Subject: New comments for application 19/01746/OUT

New comments have been received for application 19/01746/OUT at site address: Land Adj To Promised Land Farm Wendlebury Road Chesterton

Fig. 27 Proposed infrastructure plan, DTA drg no 19539—11—12 Wendlebury Road Site Access Roundabout

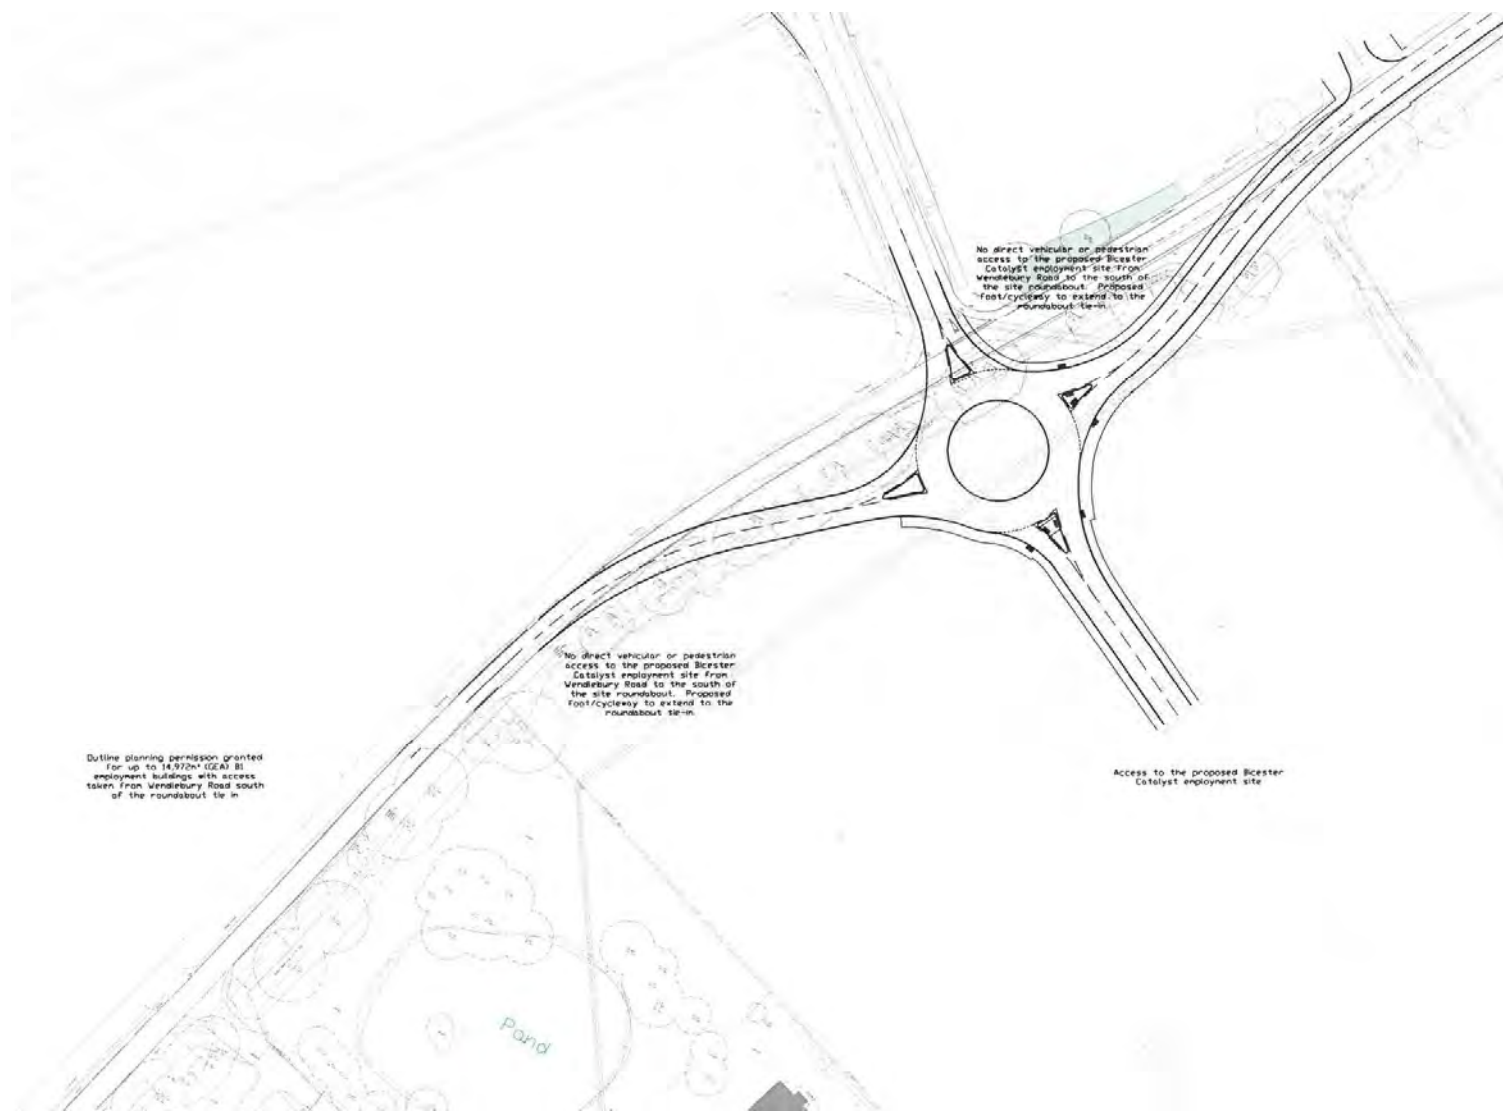
4. New roundabout should provide a protected cycle lane Given the additional car and HGV traffic (quoted as being 600-1800 cars per hour and 1000-3000 HGVs per day) then a segregated cycle path with priority over the adjoining roads in a 'dutch style' roundabout should be considered. BicesterBUG rejects the claim that the traffic level is below a supposed 'intimidation threshold'.

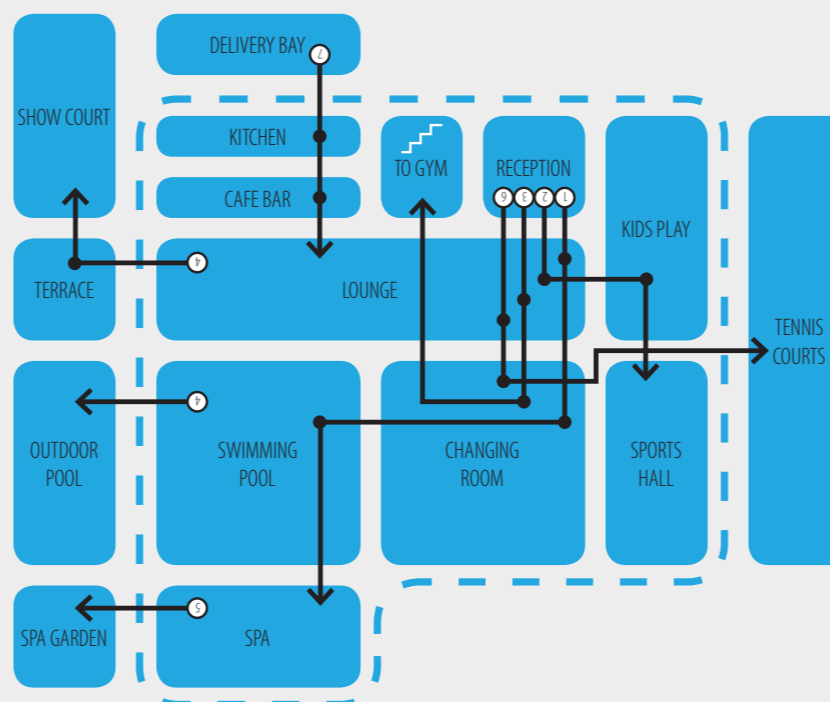
3. Insufficient cycle parking provision
The proposals list 250 car parking spaces and only 20 cycle spaces, this shows insufficient ambition regarding active travel and may contravene the OCC guidelines of 1 space per 150m²
